**KIRKLEES METROPOLITAN COUNCIL
INVESTMENT & REGENERATION SERVICE**

DELEGATED DECISION TO DETERMINE PLANNING APPLICATIONS

Reference No: 2020/62/93817/W
Site Address: 13, Clough Lea, Marsden, Huddersfield, HD7 6DN
Description: Erection of single storey extension to side (within a Conservation Area)
Recommending Officer: Laura Yeadon

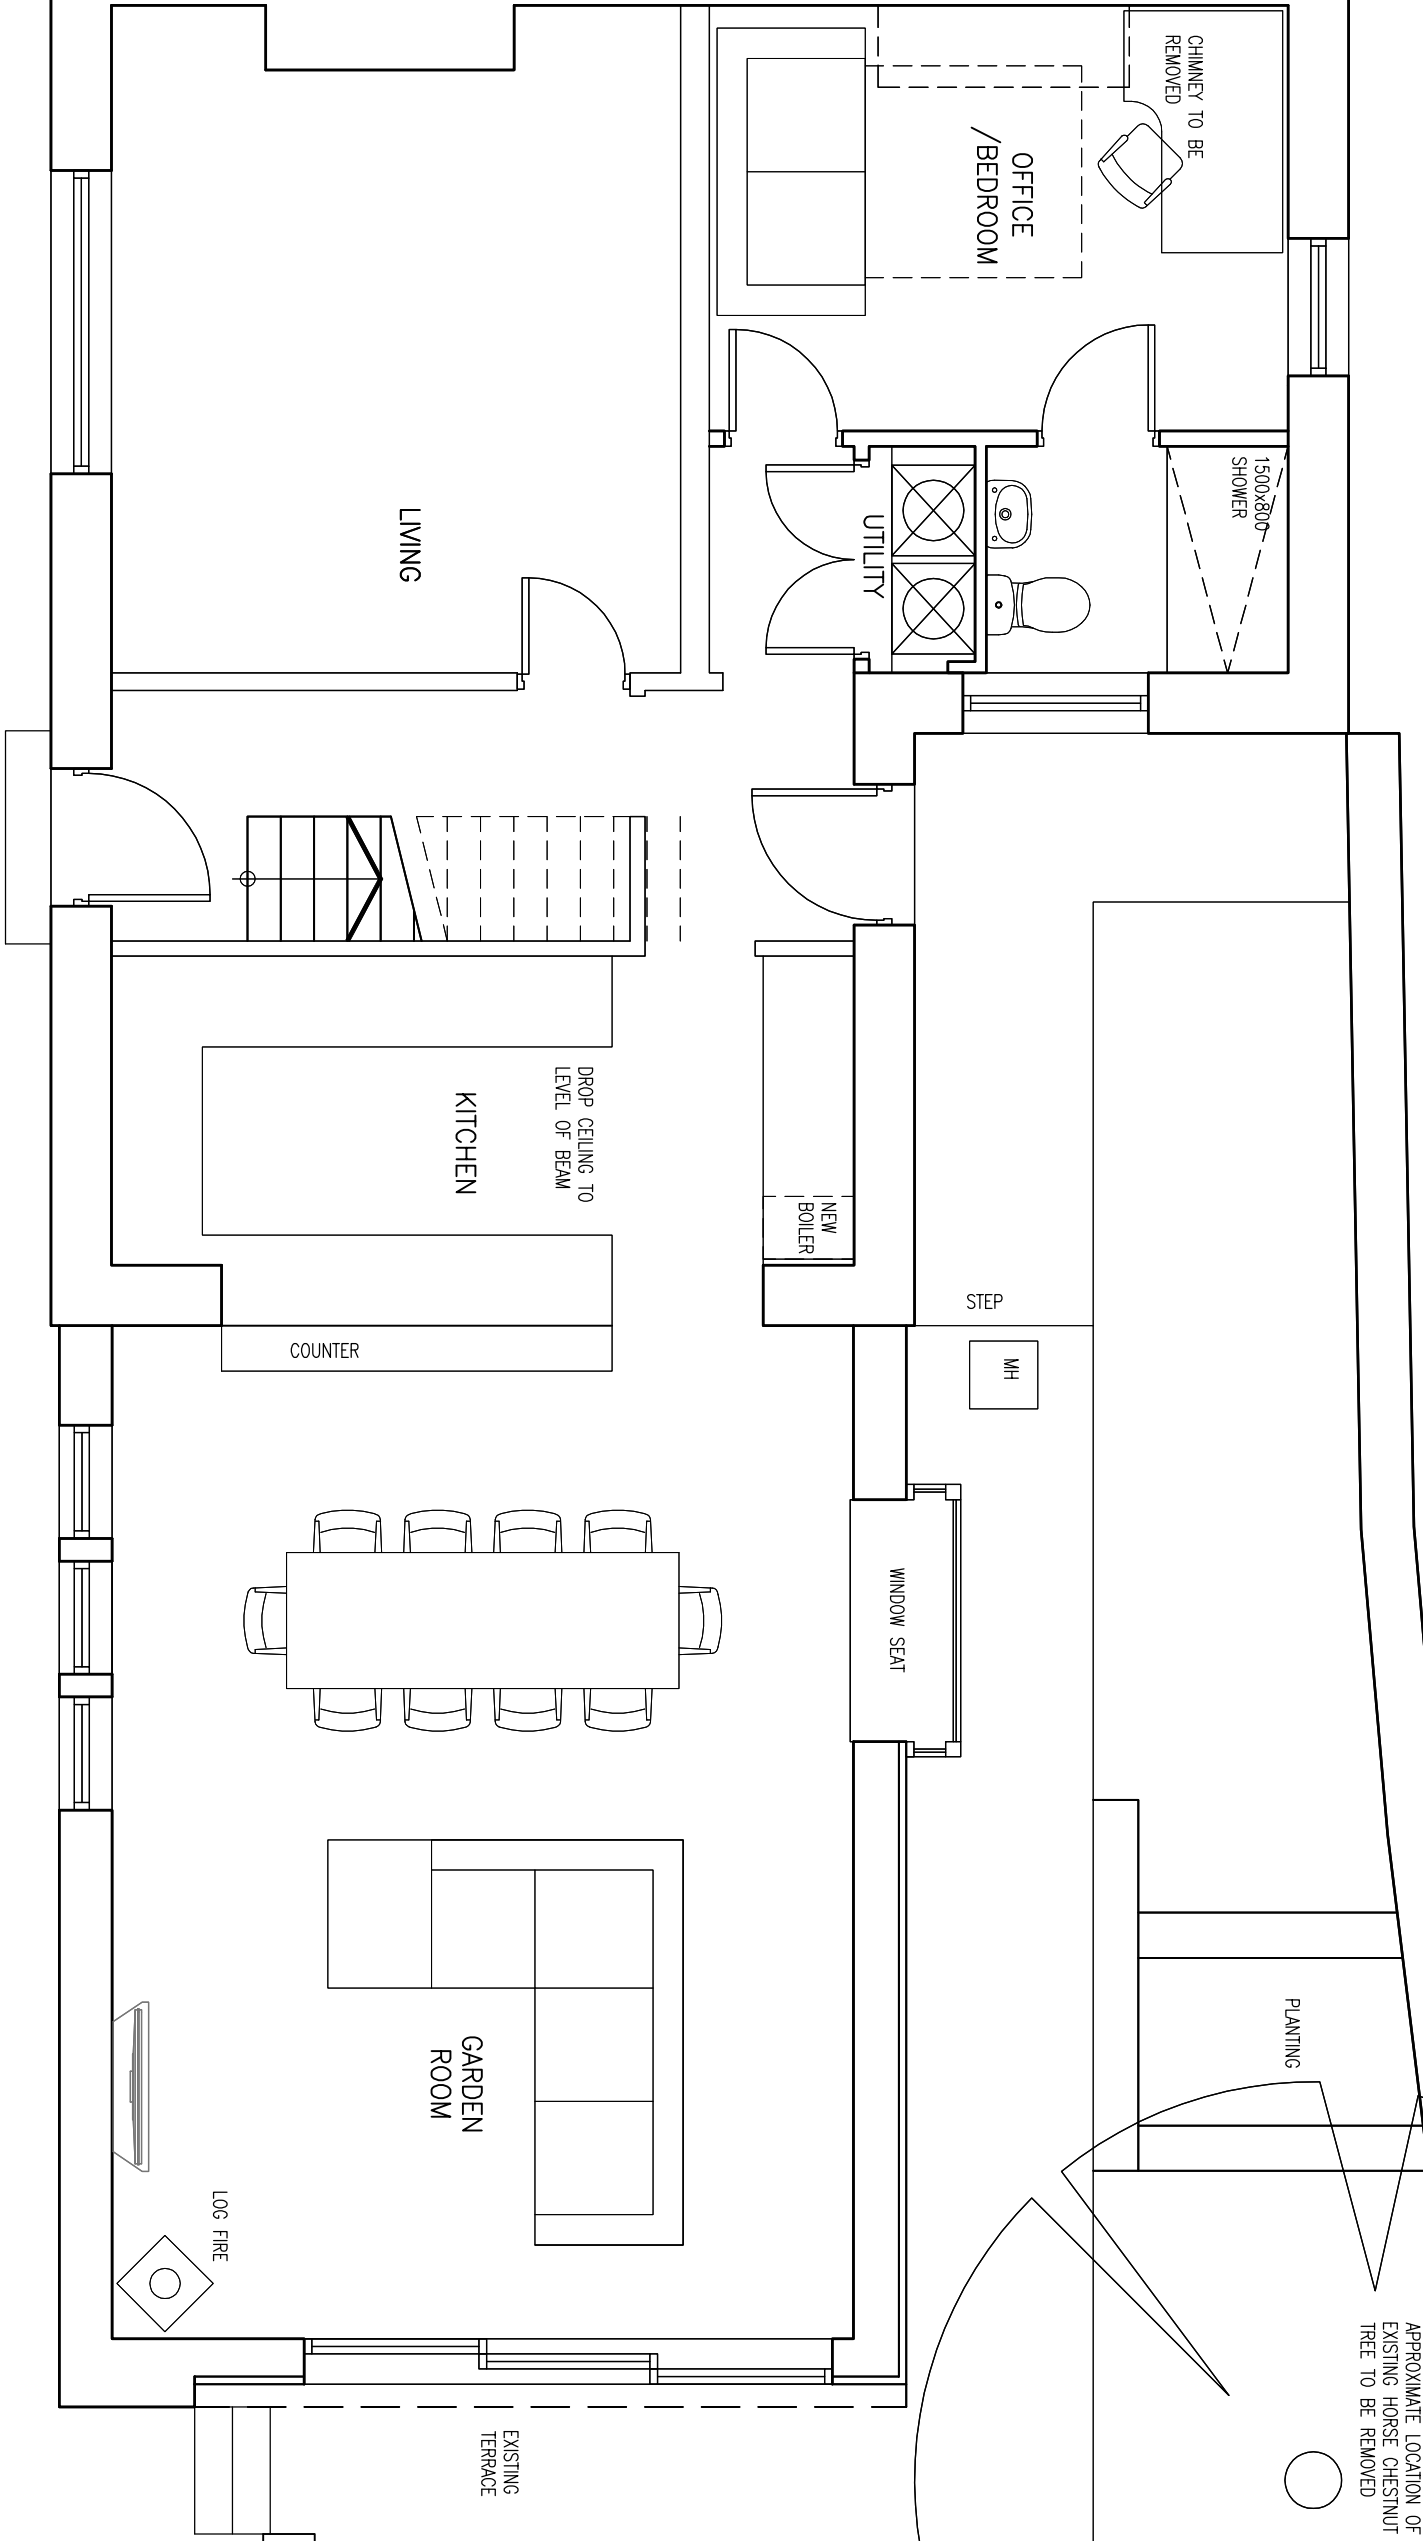
Initially, amended plans were sought as the property is within Flood Zone 2 and therefore the floor level of the extension was required to be the same as existing and the proforma was completed. Following discussions with the Conservation and Design Officer it was requested that the cladding was to be removed from the side and rear elevations, alterations to front window and an alteration to the rear window were requested. Following correspondence with the applicant, amended plans were received on 9th February 2021 and subsequently 24th February 2021 which retains the horse chestnut tree and it is these plans which shall be assessed as part of this application.

Flood risk – the property lies within Flood Zone 2 on the Council's Gazetteer. As such, a proforma was requested to be completed by the Agent. In addition, amended plans were submitted which raised the floor height of the extension to match the existing floor height. This is considered to be acceptable to adequately mitigate against flood risk.

Drawing Title:
Proposed Elevations

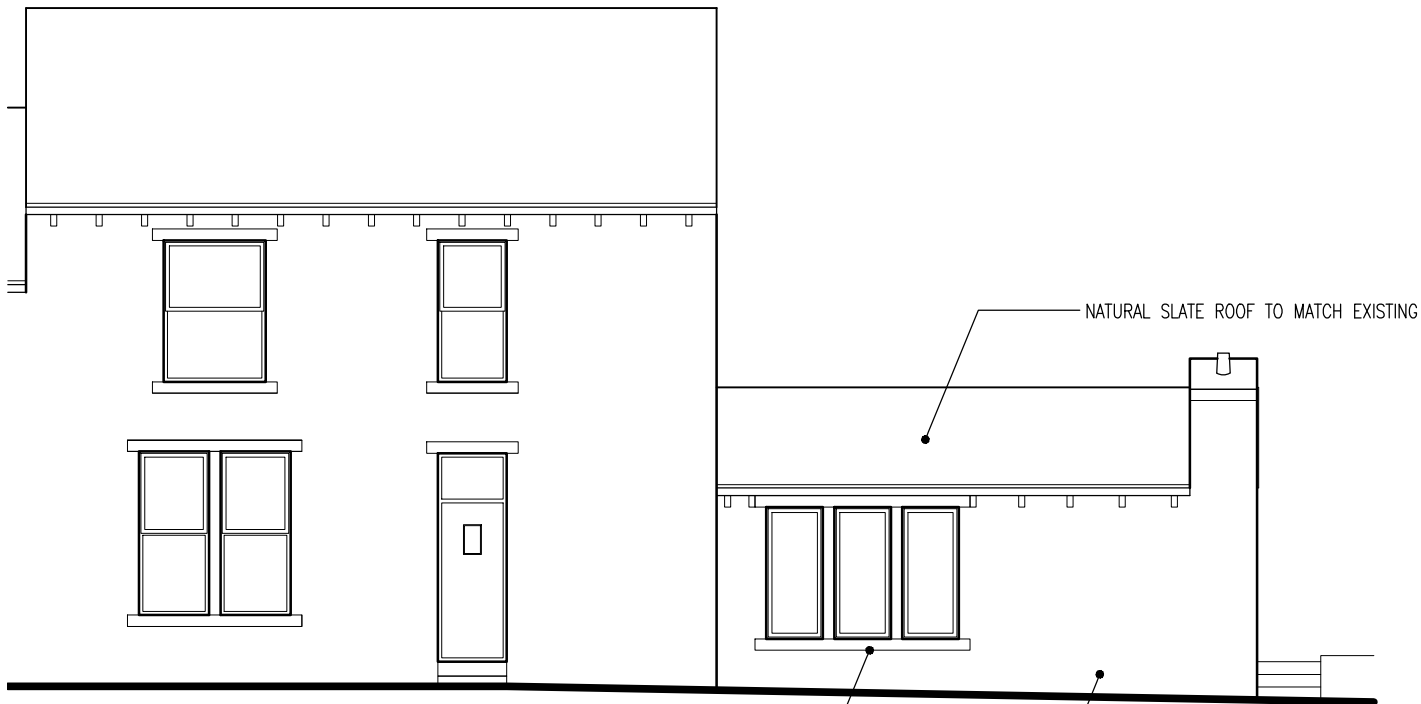
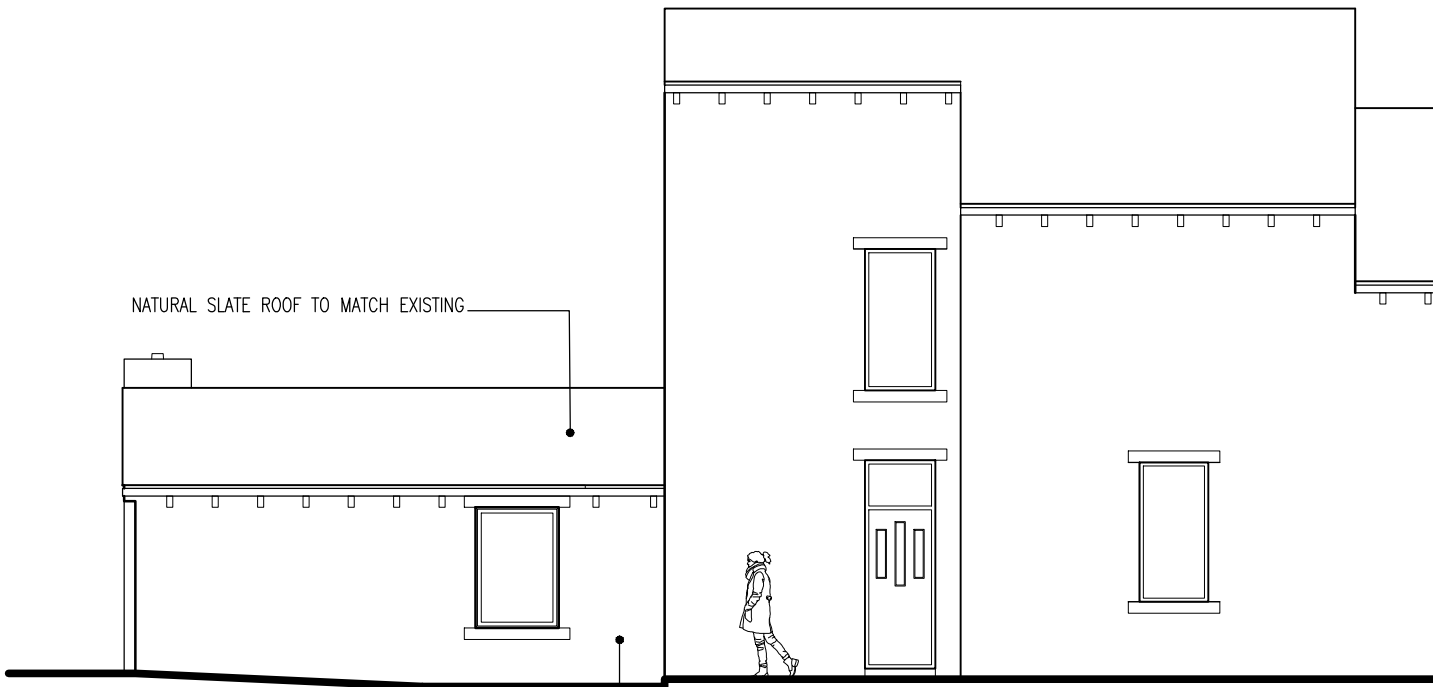
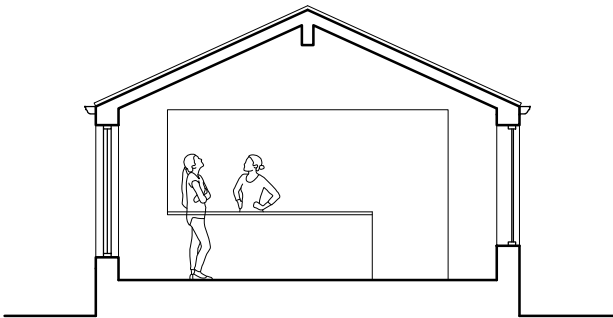
In terms of the impact on the setting of the Listed Buildings and also the Conservation Area, discussions have taken place and amendments sought. It is considered that the proposal would not result in harm to the setting of the listed building or the character and appearance of the conservation area. The extension would appear as an organic addition to this linear row, and would not compete for prominence with the existing structures. Policy LP35 requires proposals to maintain local distinctiveness and preserve and enhance the significance of heritage assets. It is considered that in this instance, modernising, extending and generally renovating the existing property to retain its future use as a dwelling meets this test.
